**WELWYN HATFIELD COUNCIL – DEVELOPMENT CONTROL**  
**DELEGATED REPORT**

<b>APPLICATION No:</b>	<b>S6/2007/1711/LB</b>
------------------------	------------------------

The demolition of the existing modern additions and fire escape to the eastern side of the main building. A single storey side extension with two roof lanterns would be erected over this area. The proposal would also involve the construction of a basement under the approved rear extension within application S6/2007/422/FP. This addition would have a light well to the eastern side and smaller light wells to the rear and western elevations of the approved extension. Within the building 7 vaults would be restored with one being converted into a WC and another being converted into a store.

Drawing Title : Proposed
Ground Floor Layout

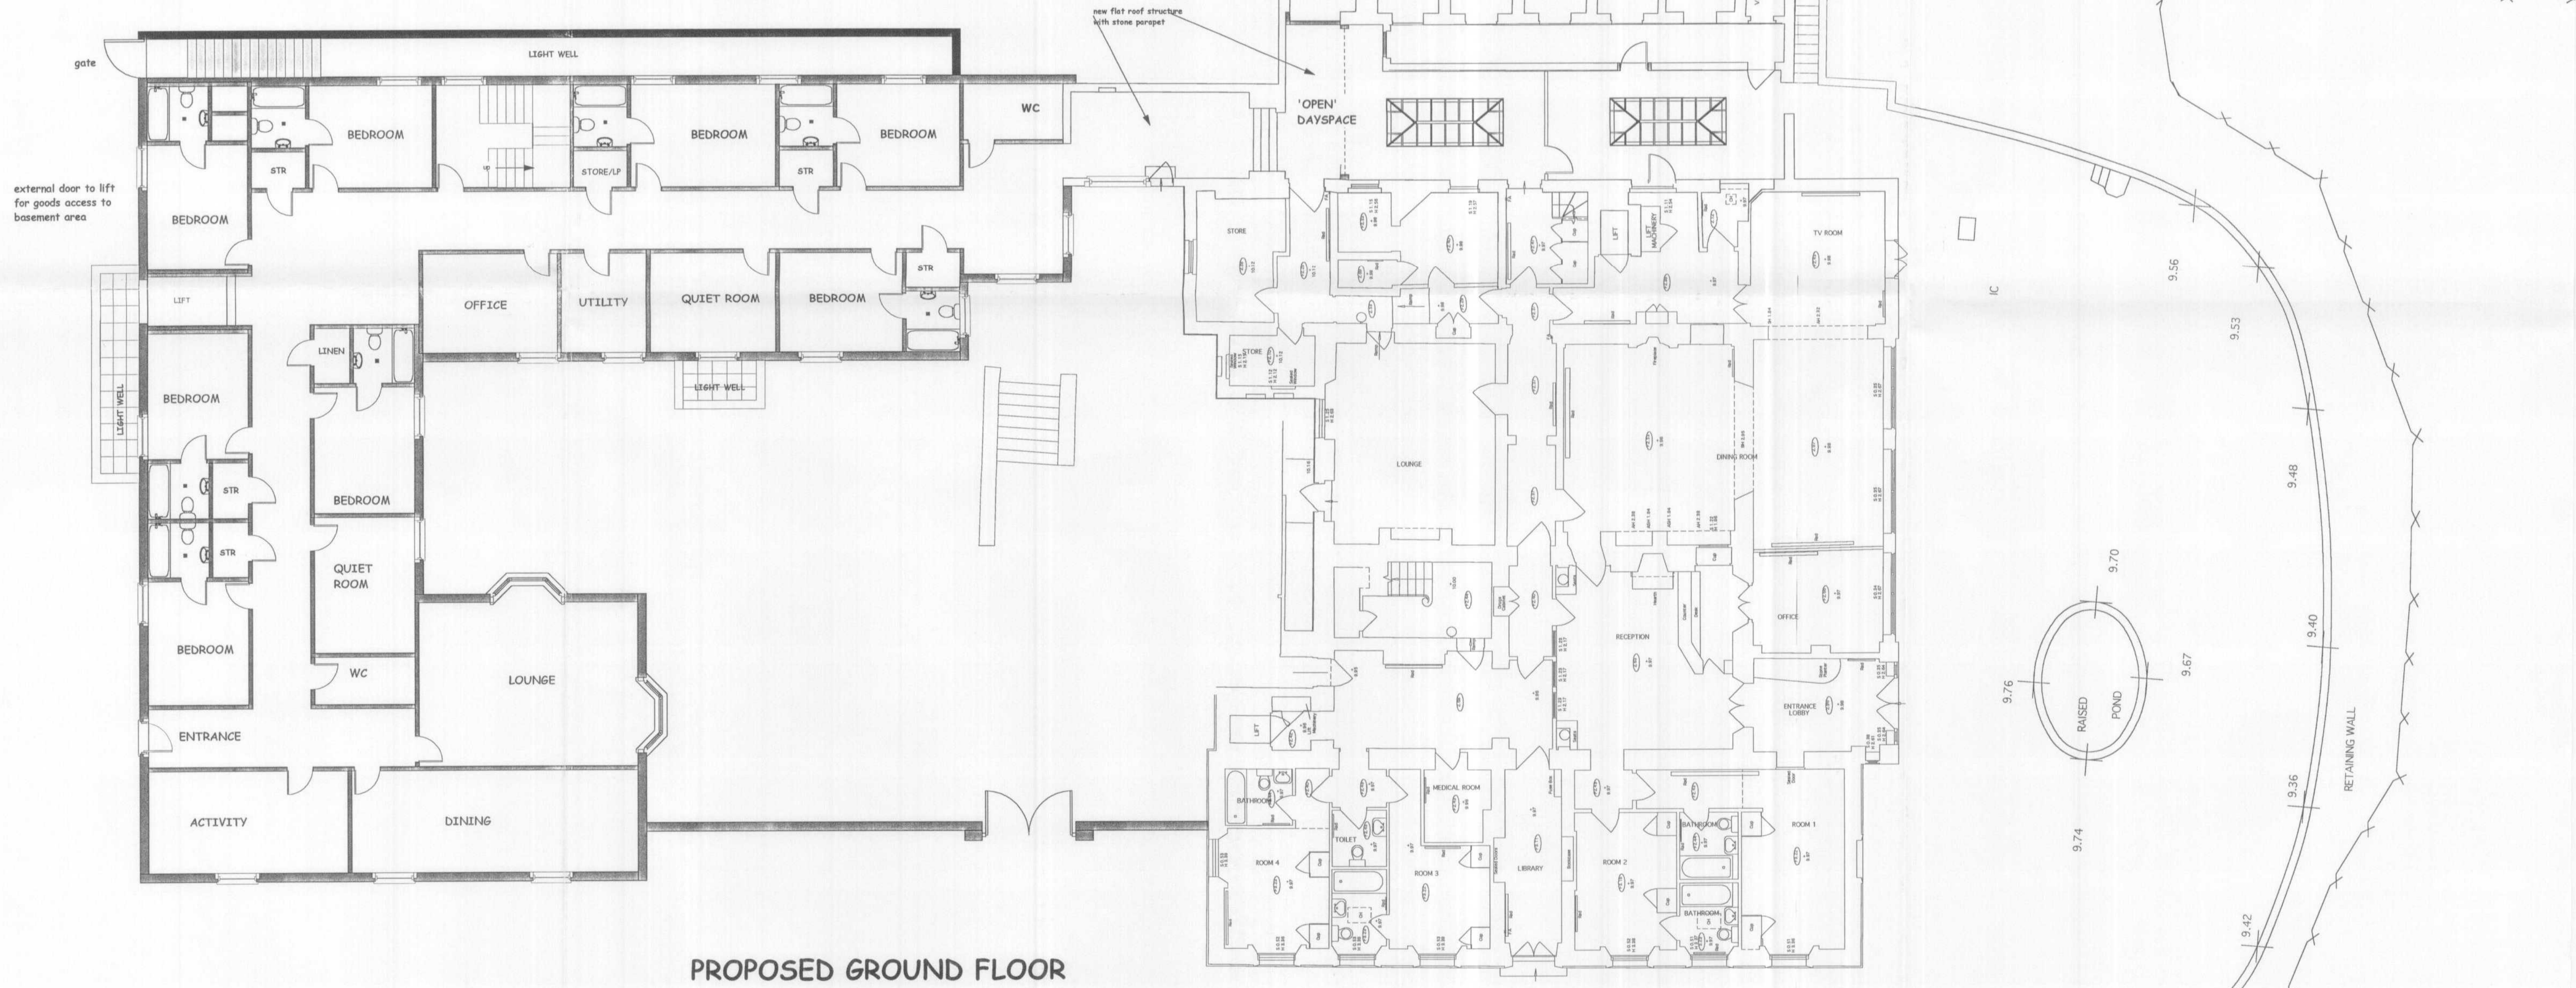
The eastern side of the existing building does not have as great importance as the western elevation. The eastern elevation currently has a more functional appearance with a fire escape and plant/machinery. The proposed development would replace the fire escape and enclose the area to the side with a single storey extension. The proposed light well to the east would have a railing and brick piers matching those approved to the courtyard area. When viewed from the east the proposed development would appear subordinate to the main building. Views of the proposed alterations to the east of the building would be limited due to the adjacent land being on a higher ground level and the existing tall boundary treatment. The proposed development would give the site a more uniform appearance to the east and would not have an adverse impact upon Listed Building.

To the rear and west small light wells would be enclosed by brick pillars and railings. These additions would be viewed against the approved extensions and would not appear prominent or out of place.

Drawing Title : Proposed
Sections and Elevations

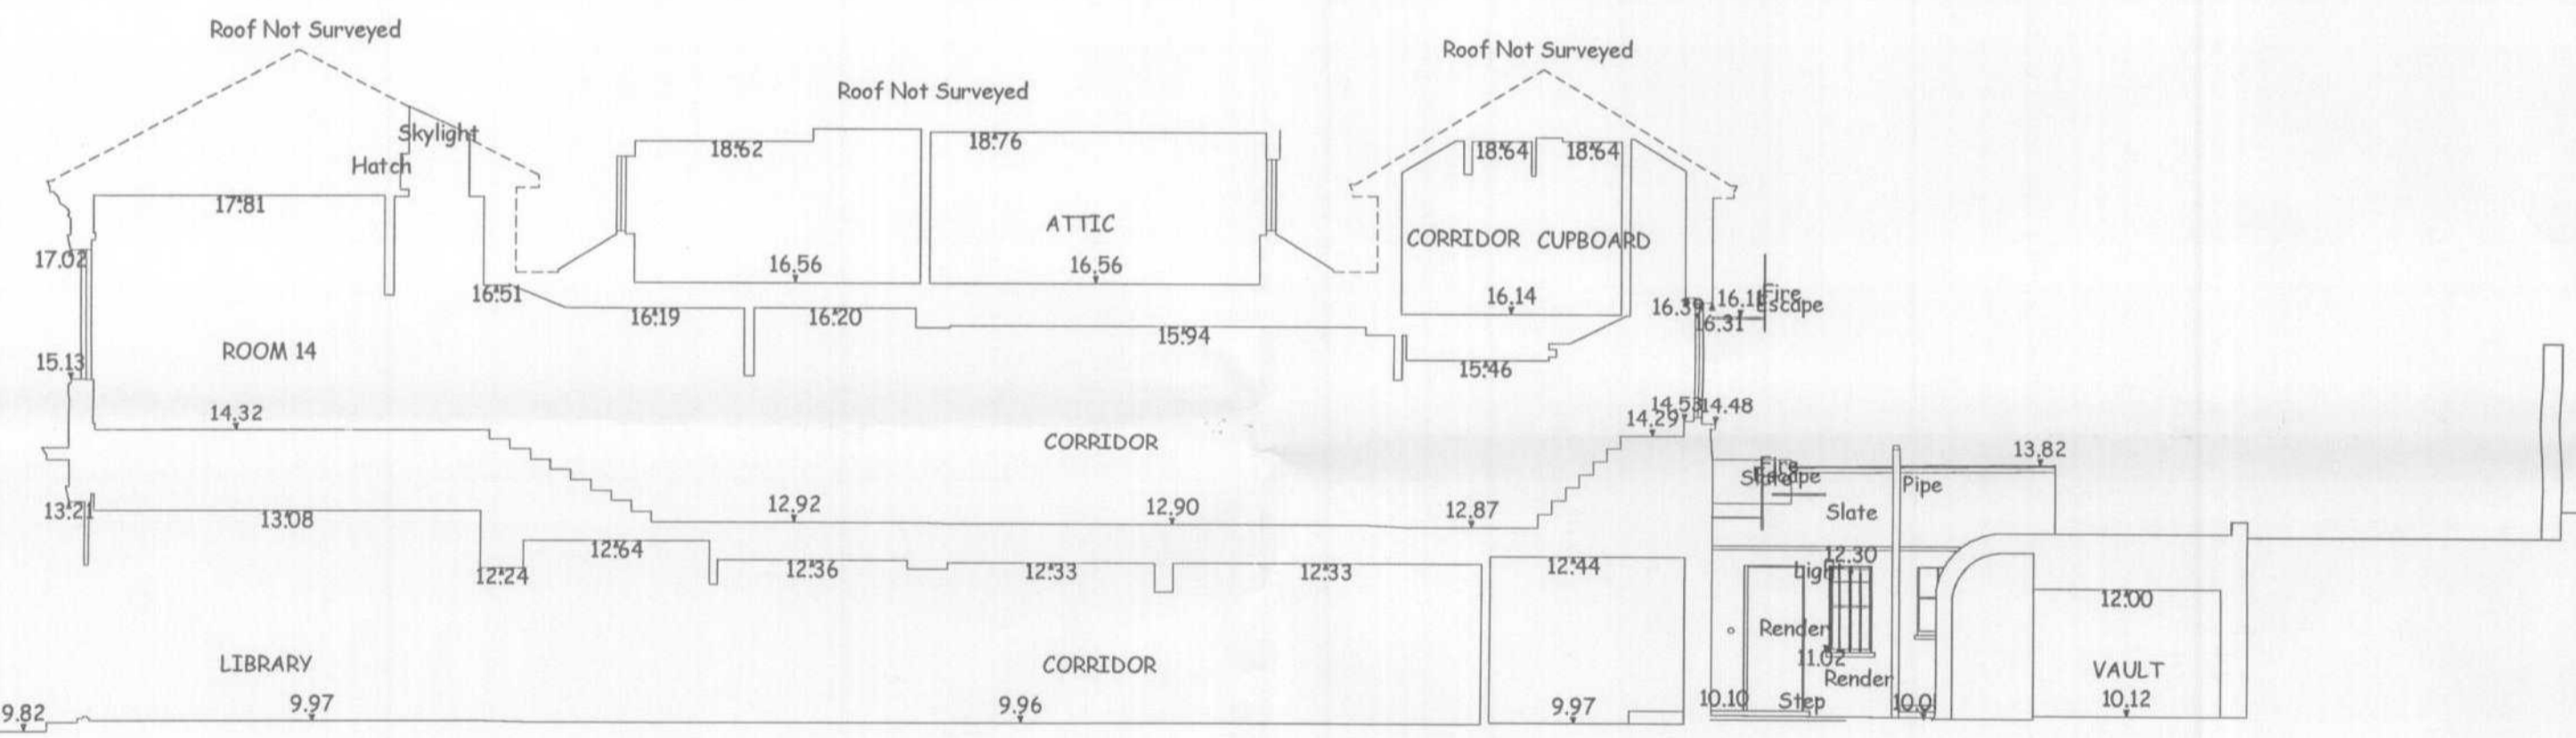
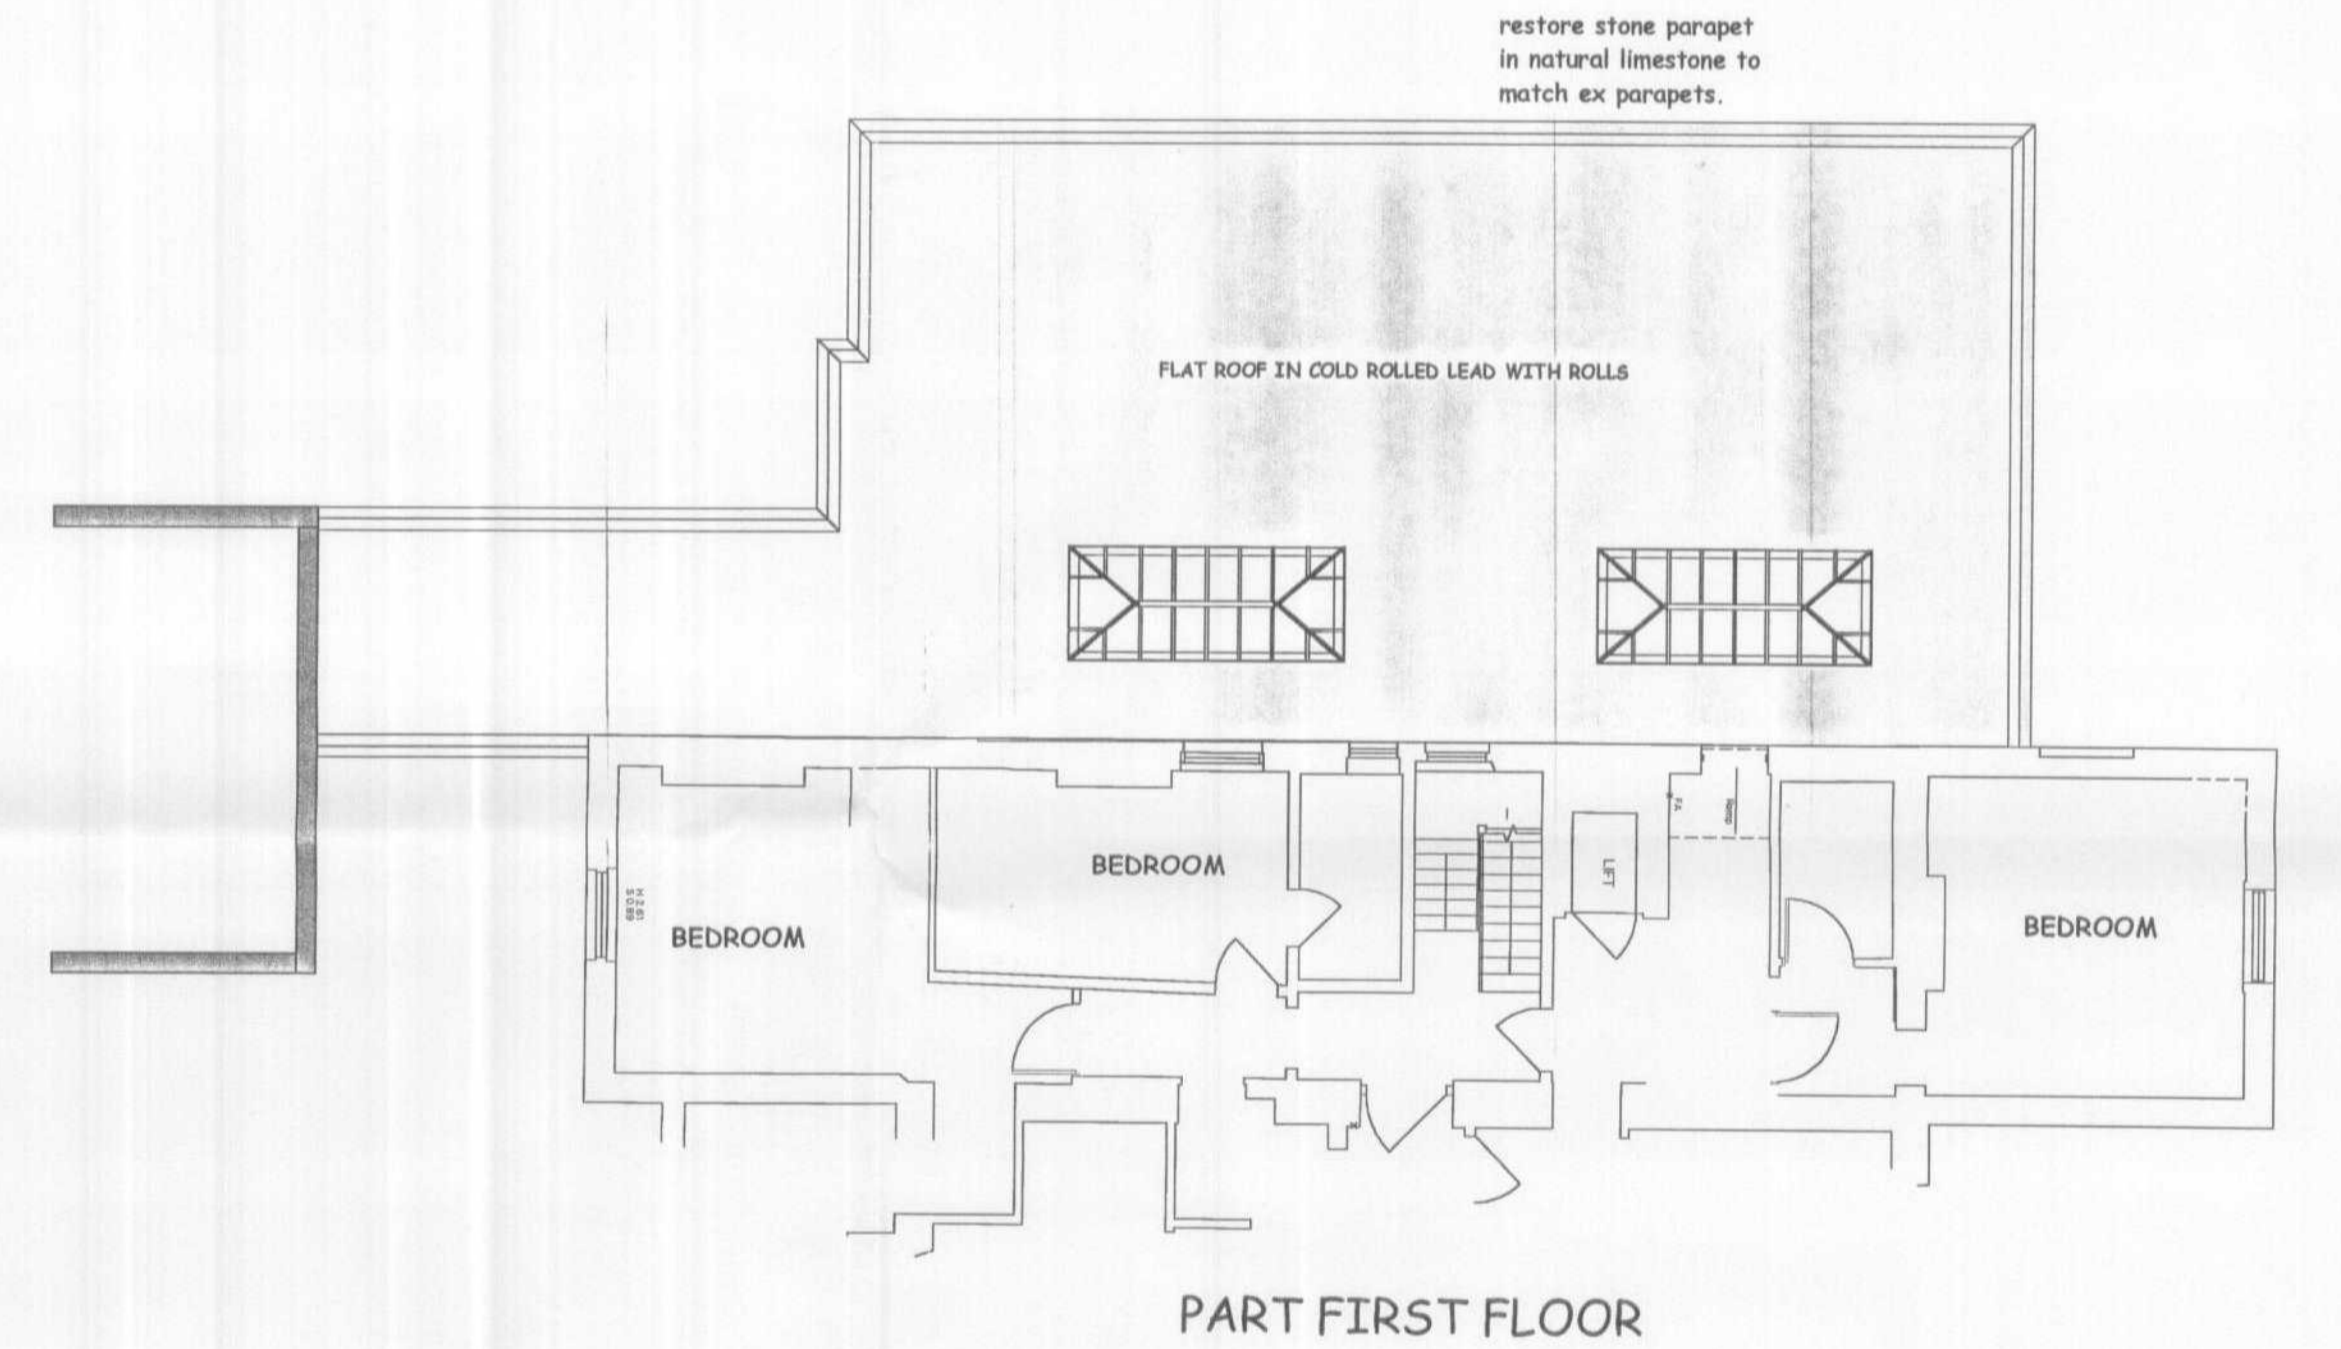
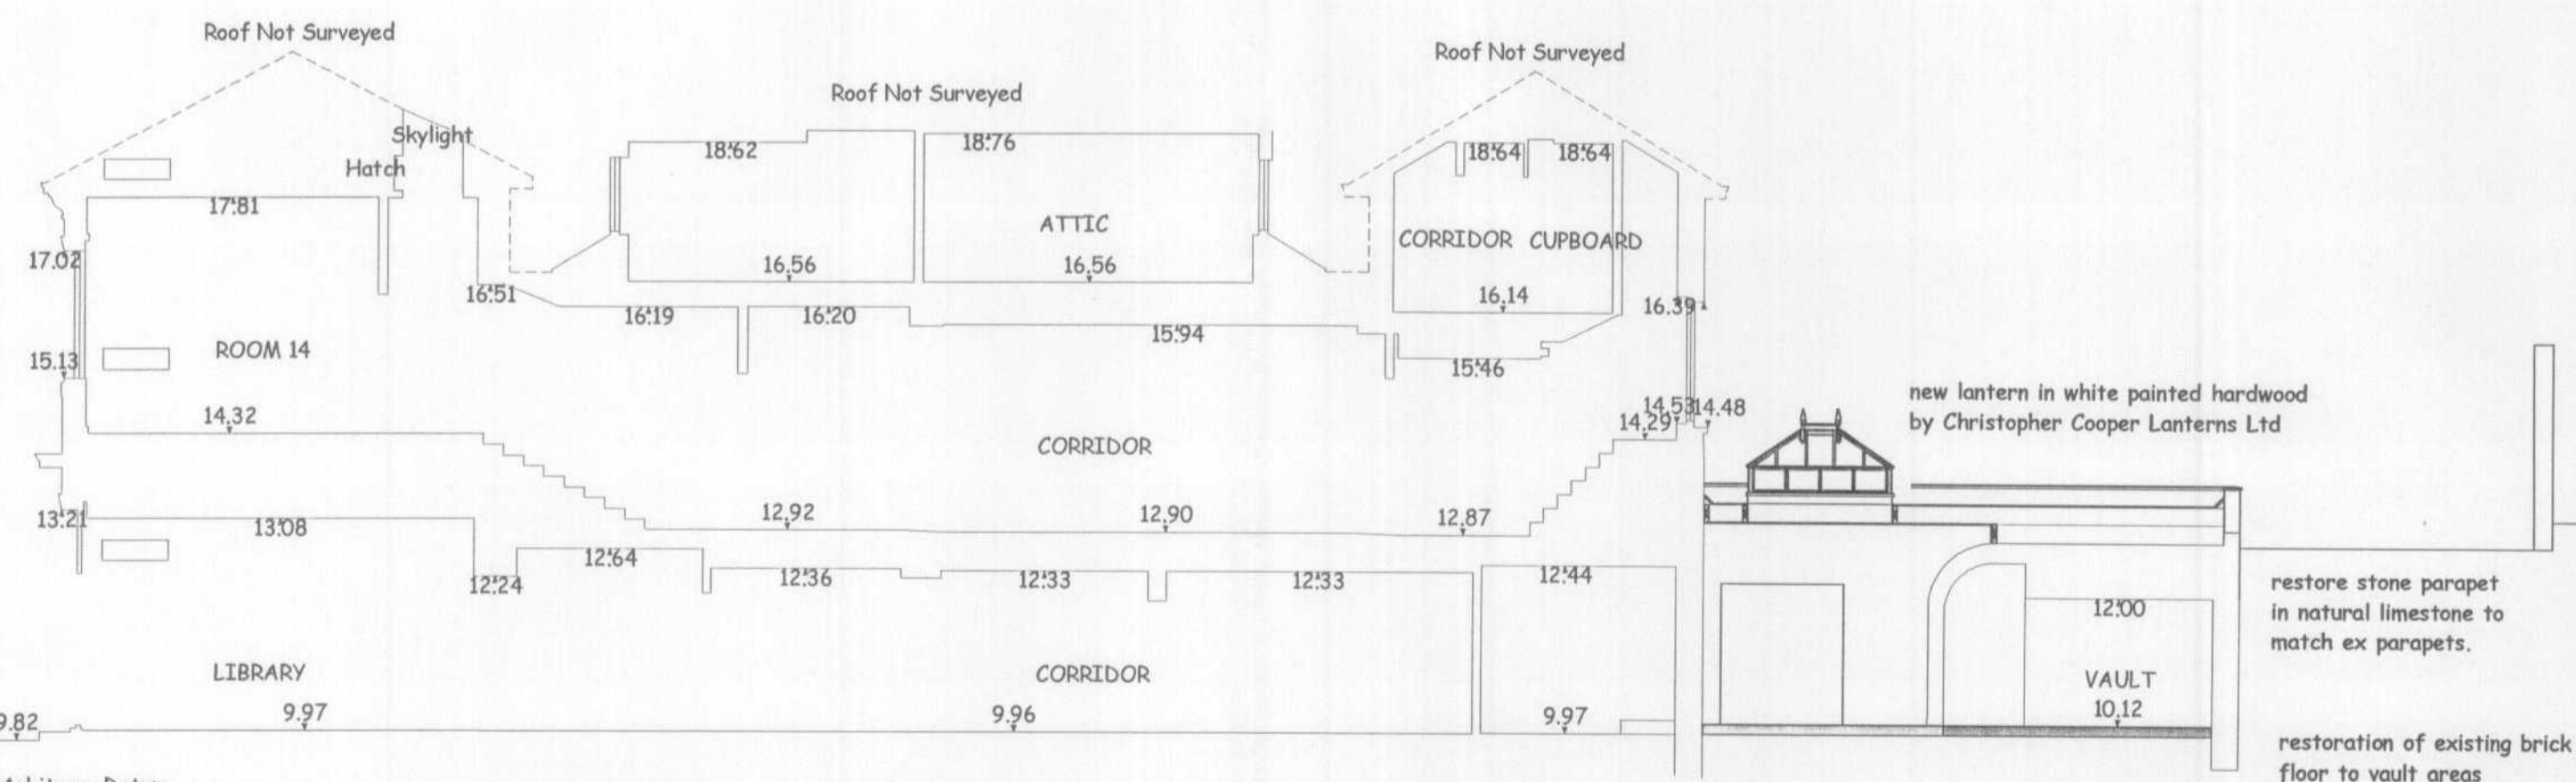
Within the previous application alterations were requested to alter the window heads and arches to be brick rather than haddenstone. The drawings have not yet altered this feature, therefore any consent would need a condition to ensure this is done prior to construction.

Within the building there is an area which contains 7 vaults which have historic importance. These would be retained with one being converted to be a WC and another being used for storage. The retention of this area is considered to be important and the proposed restoration is considered to be appropriate.

1. C.2.2 – Time Limit Full Permission (Listed Buildings)
2. C.5.1 – Material to be submitted
3. C.9.3 – Full Archaeological Excavation and Evaluation
4. Notwithstanding the details on the approved plans, full details of amended elevations showing brick headstones and arches are to be submitted and approved in writing. Notwithstanding the provisions of the provisions of the Town and Country Planning, General Permitted Development) Order 1995 (or any Order revoking and re-enacting that Order with or without modification) no additional windows or similar openings shall be constructed in the flank elevation of the original dwelling and extension hereby permitted except for any which may be shown on the amended drawing(s) to be approved after the approval of this application.
